STATE OF NORTH CAROLINA
DEPARTMENT OF TRANSPORTATION

Addendum No. 1

RE: Contract ID C203488

I-240 From I-40/I-26 To US-19/23

PROJECT NO.	SHEET NO.	TOTAL SHEETS
45830.3.FS1	PM-1

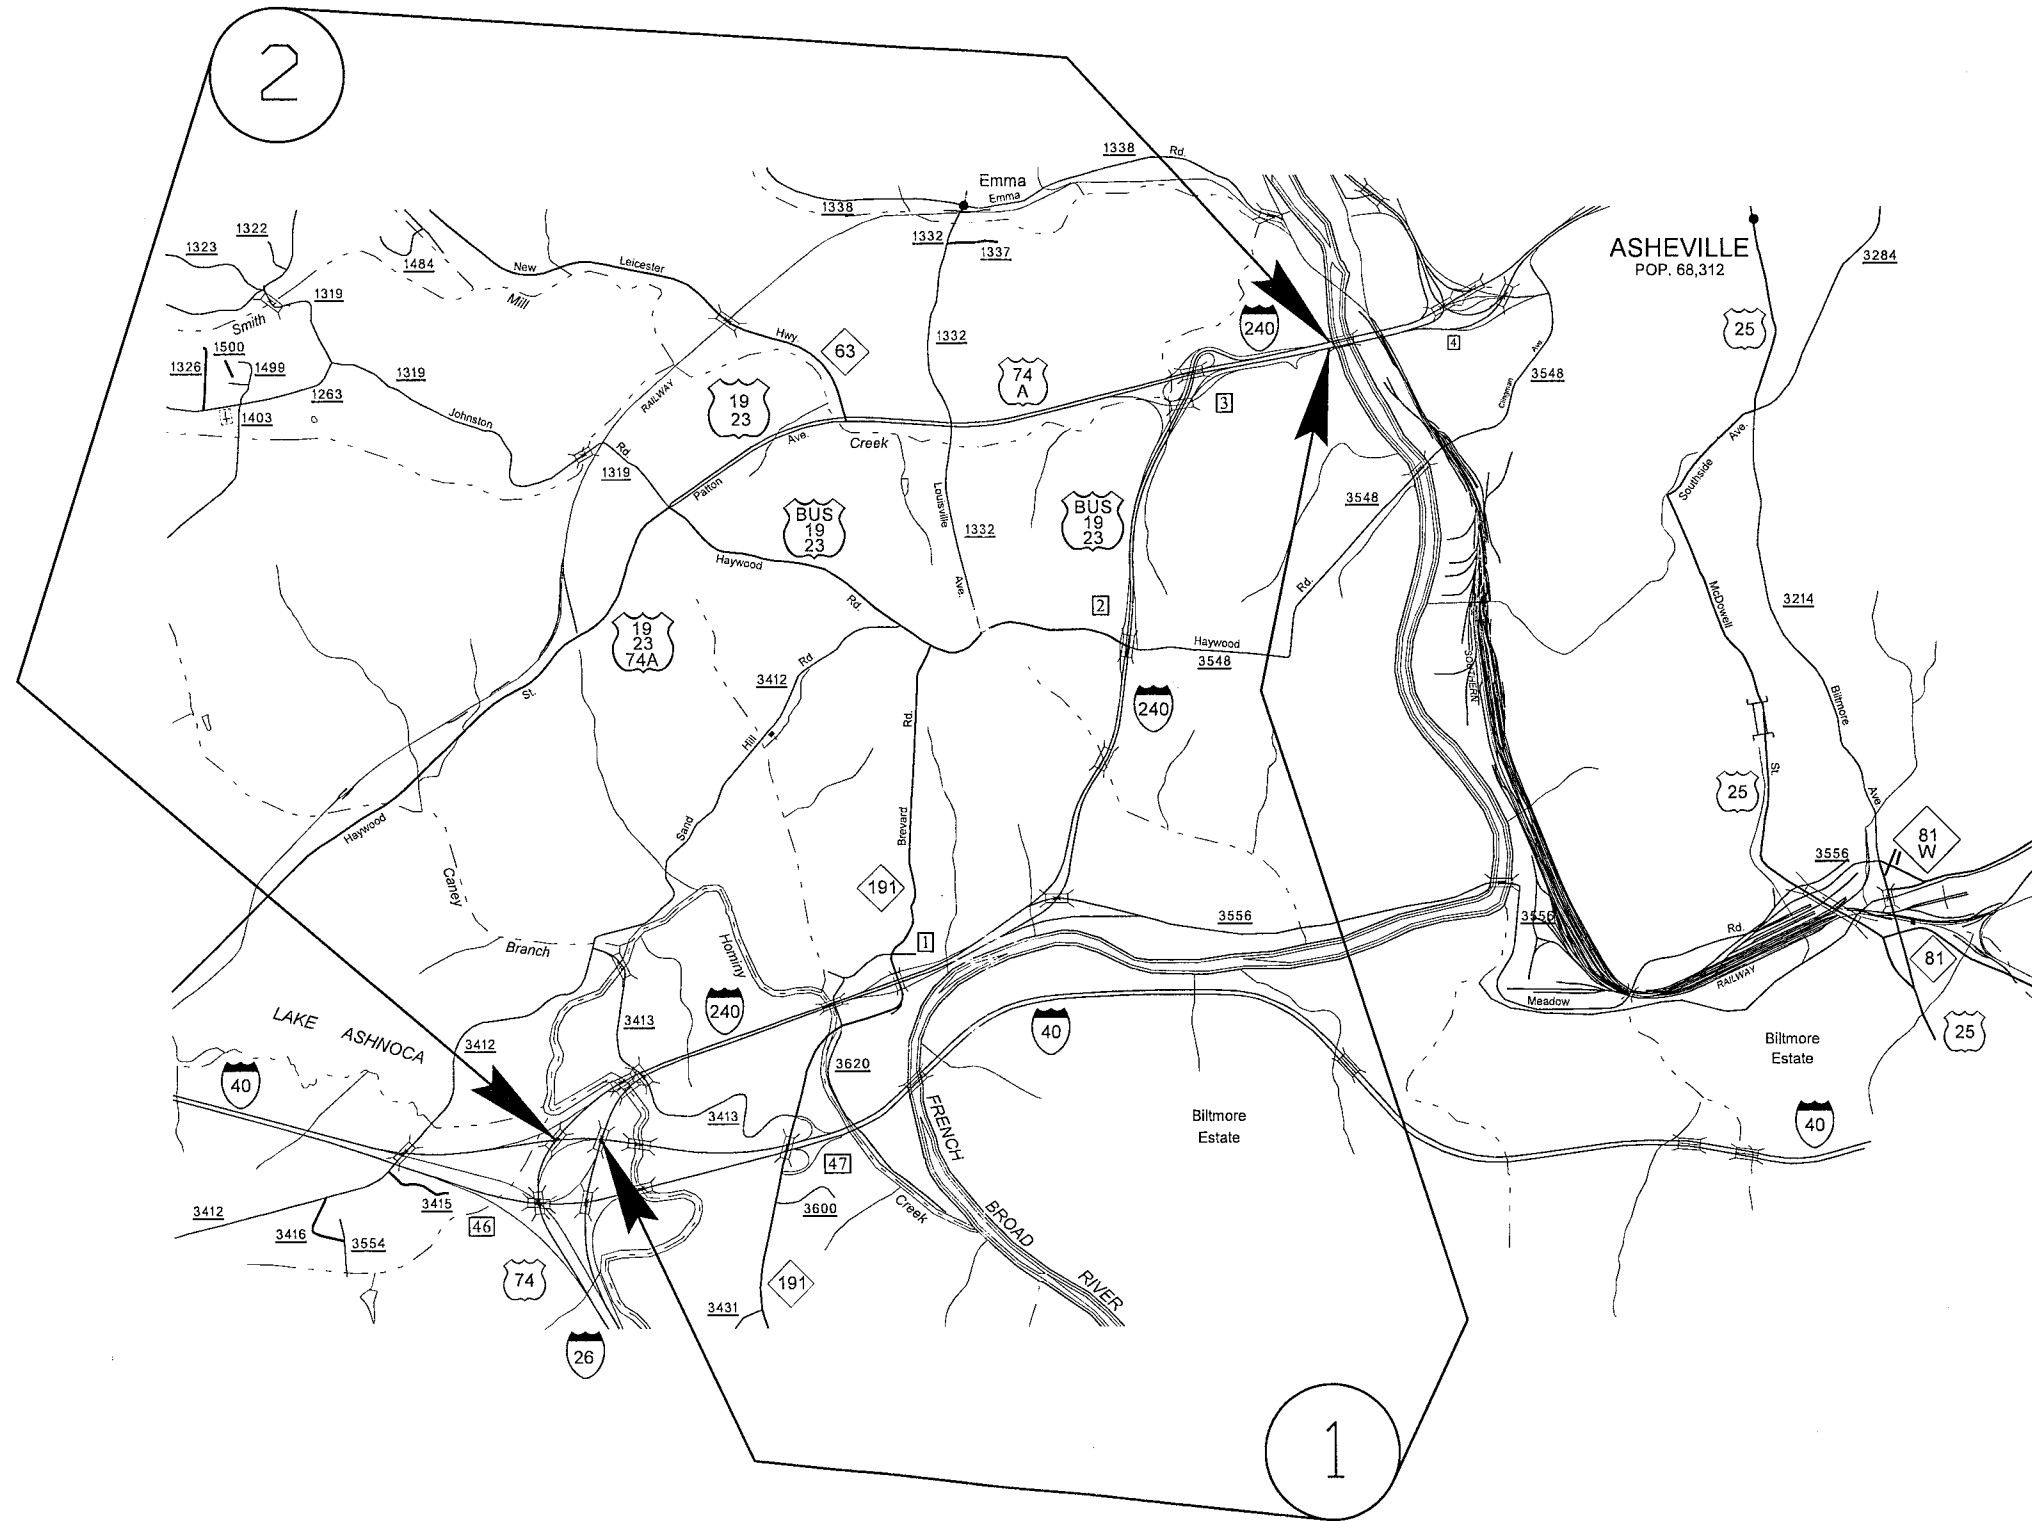
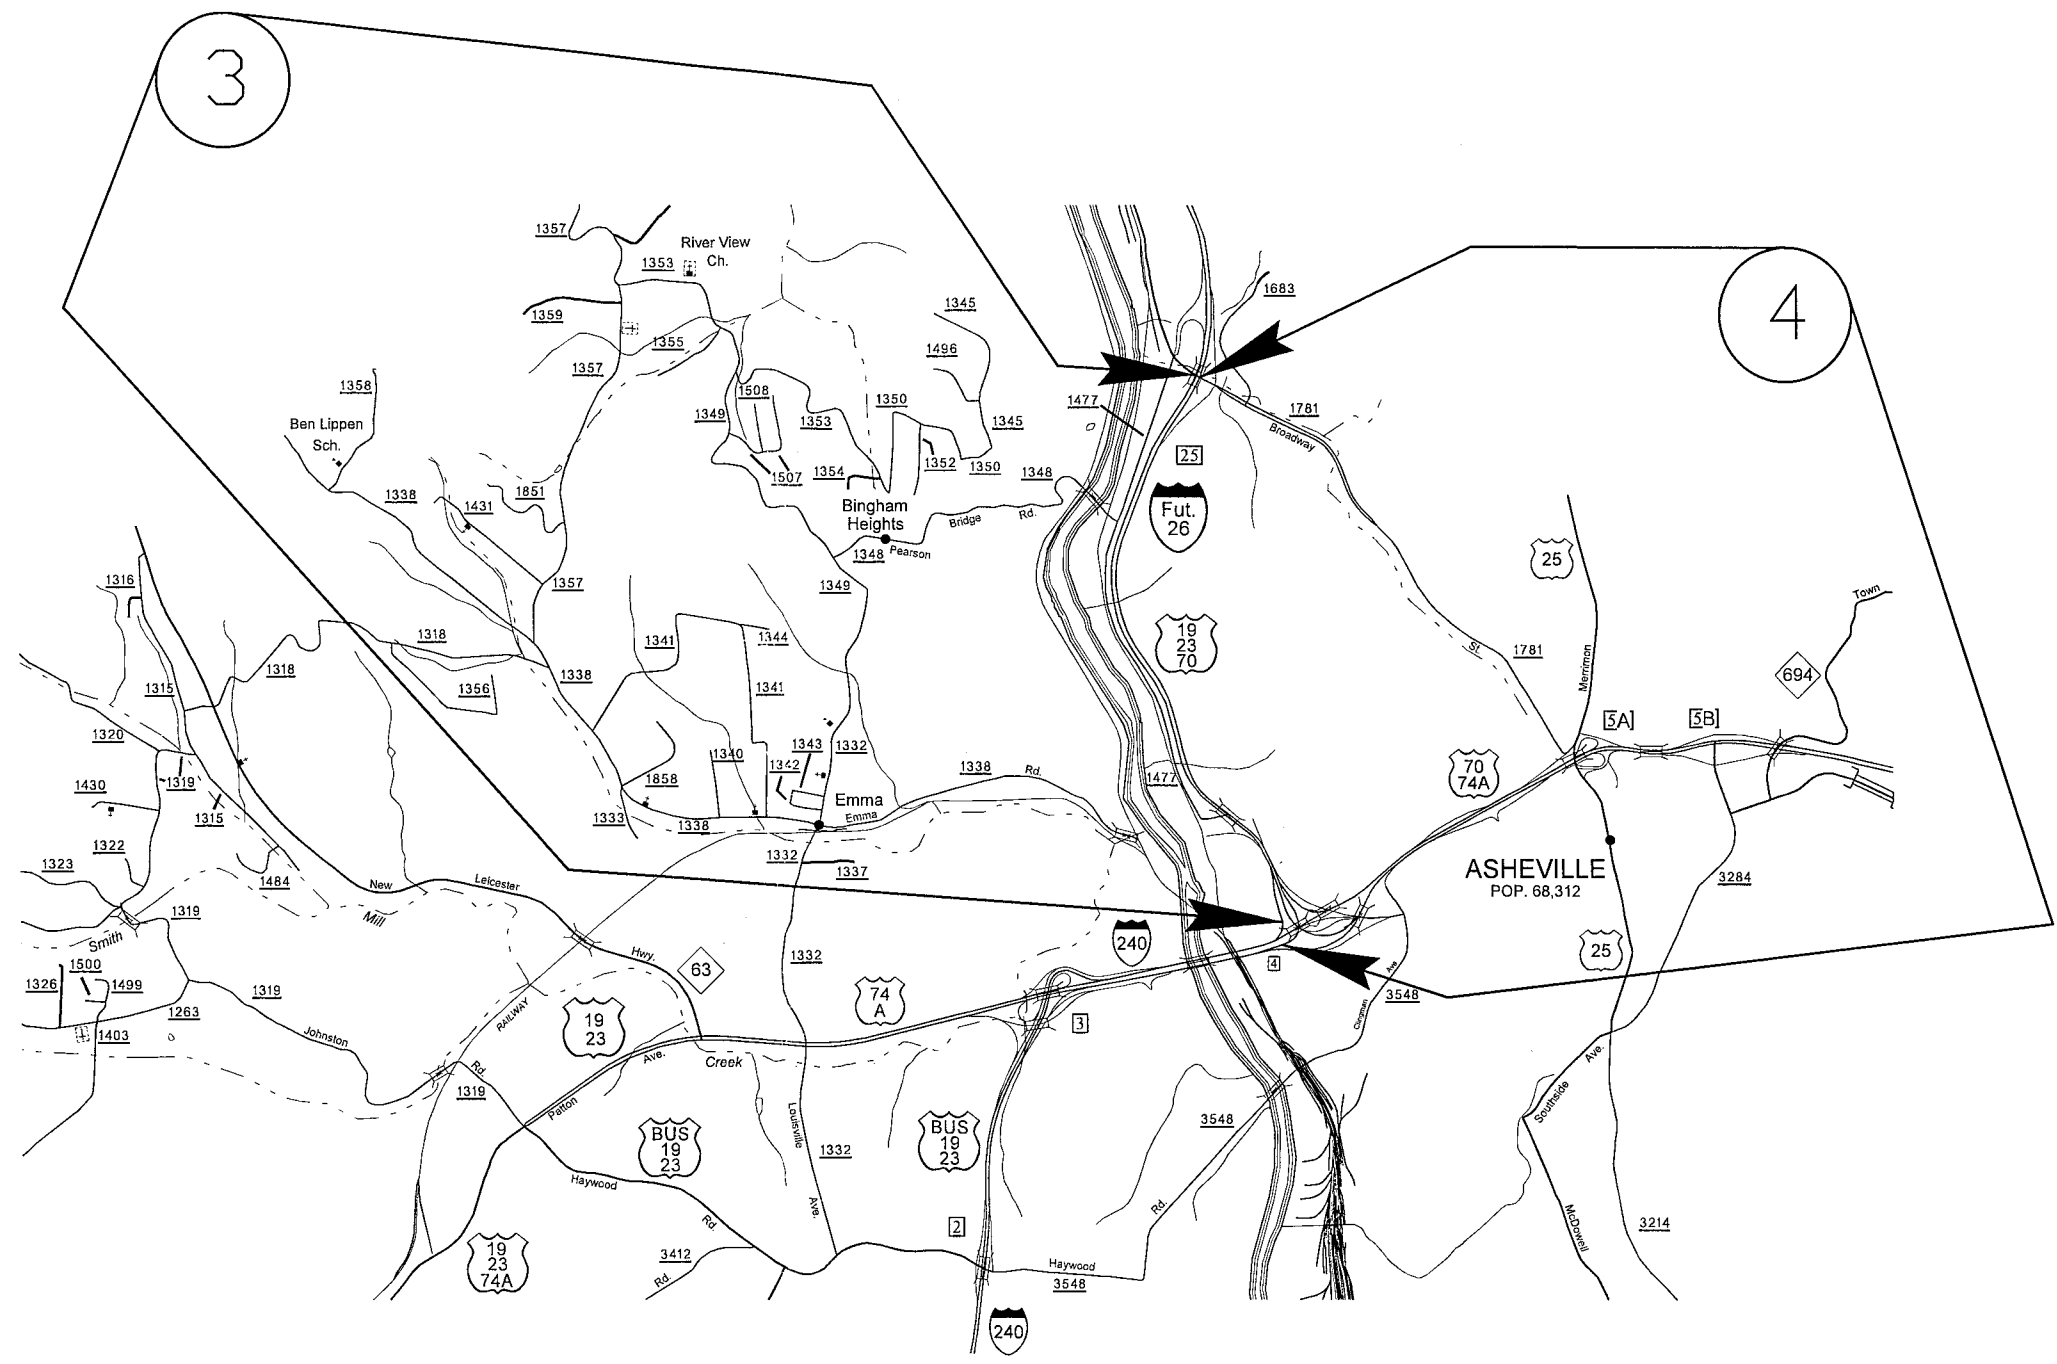
Sheet No. PM-1 has been revised to correct the route number. Please void Sheet No. PM-1 in your plans and staple the revised Sheet No. PM-1 thereto.
